**Our Case Number:** ABP-314610-22

**Re:** BusConnects Ballymun/Finglas to City Centre Core Bus Corridor Scheme  
Ballymun/Finglas to Dublin City Centre

**RE: Ballymun/ Finglas to City Center Core Bus Corridor**

**An Bord Pleanála Case No. 314610**

TYPICAL SECTION M-M
CONSTITUTION HILL
LOCATED ON GA SHEET 16
DRAWING REF: BCIDD-ROT-GEO_GA-0304_XX_00-DR-CR-0016

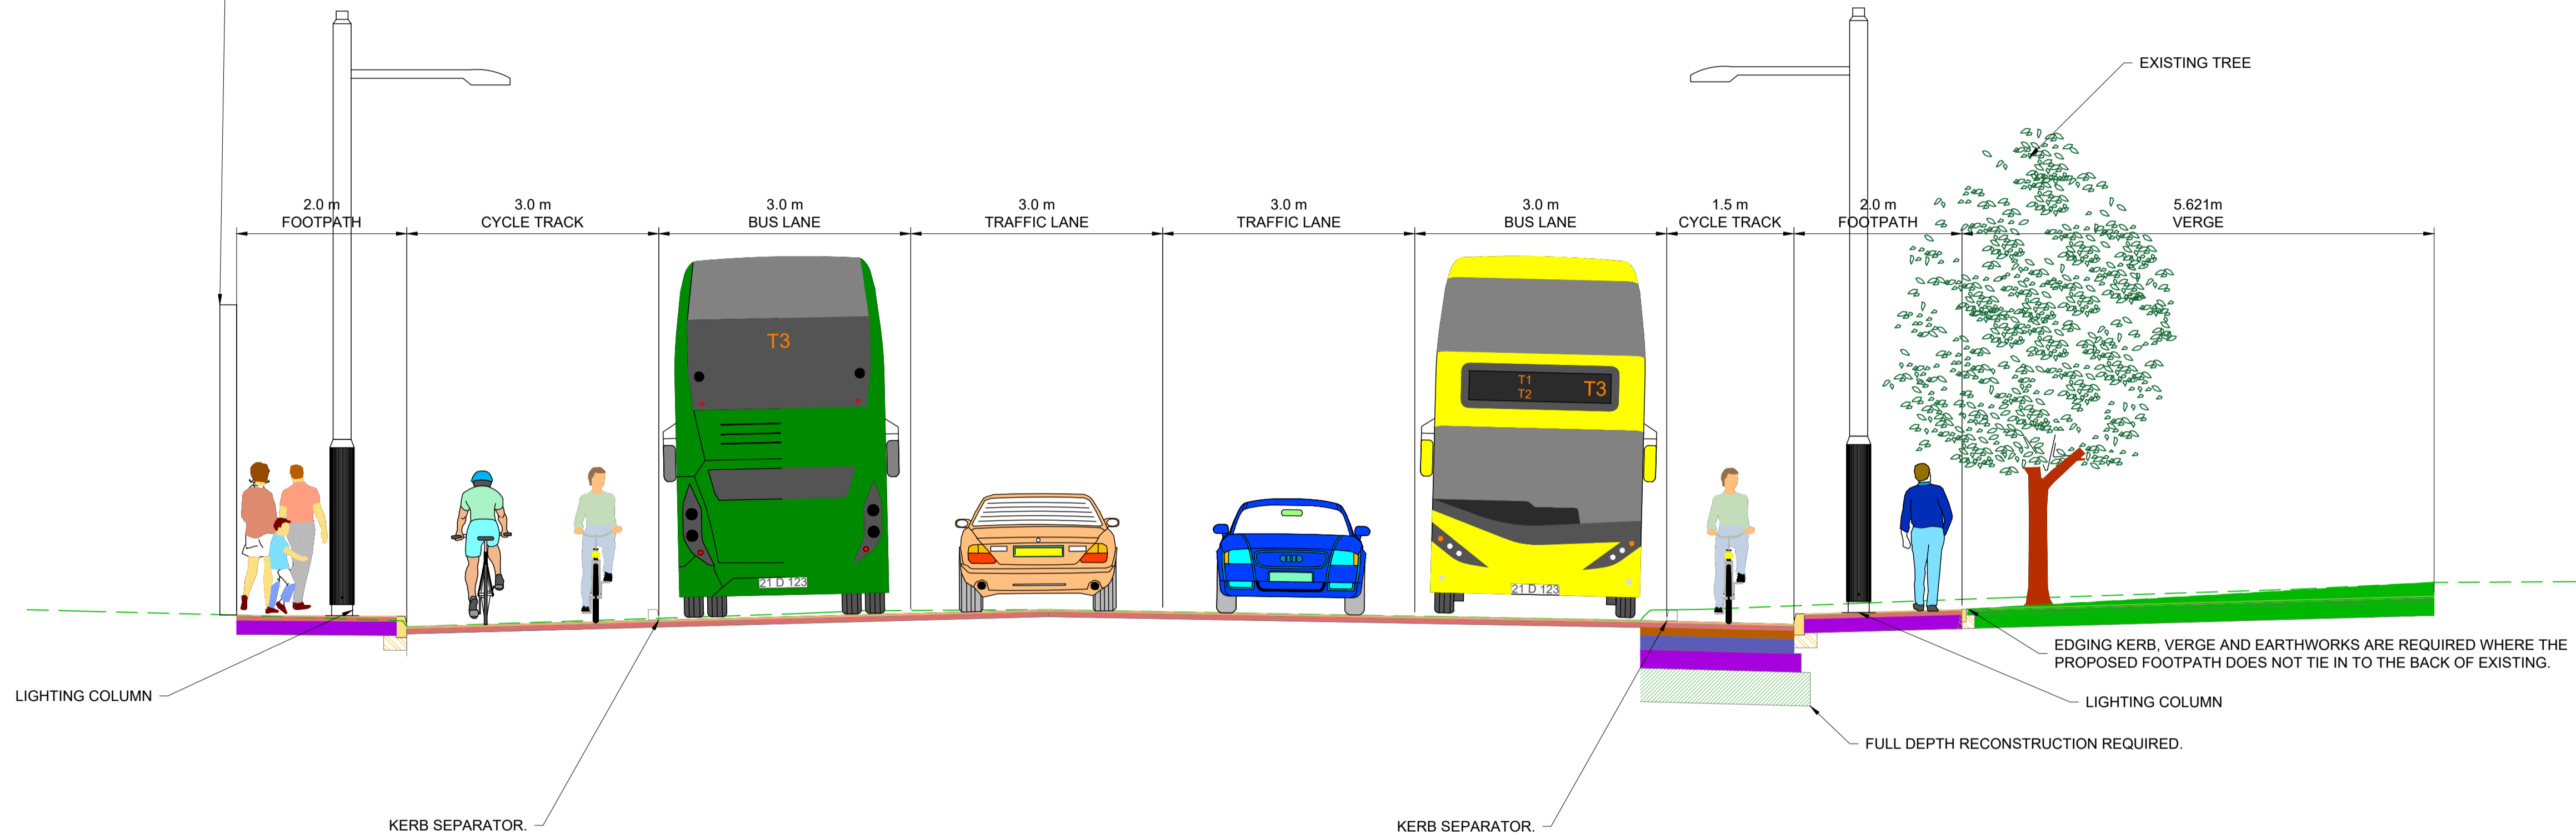
We object to the proposals in General Arrangement Drawings Sheets 15-18, which show Phibsborough Village. Phibsborough Village is the focal point for Cabra-Glasnevin area is home to approximately 59,000 people as of the 2016 Census. Phibsborough is designated as a 'Key Urban Village' in the Dublin City Development Plan (Chapter 7, 'City Centre Urban Villages and Retail, 2022). The applicant's proposals will significantly shape the public realm and desirability of transport options at the heart of this key urban village.
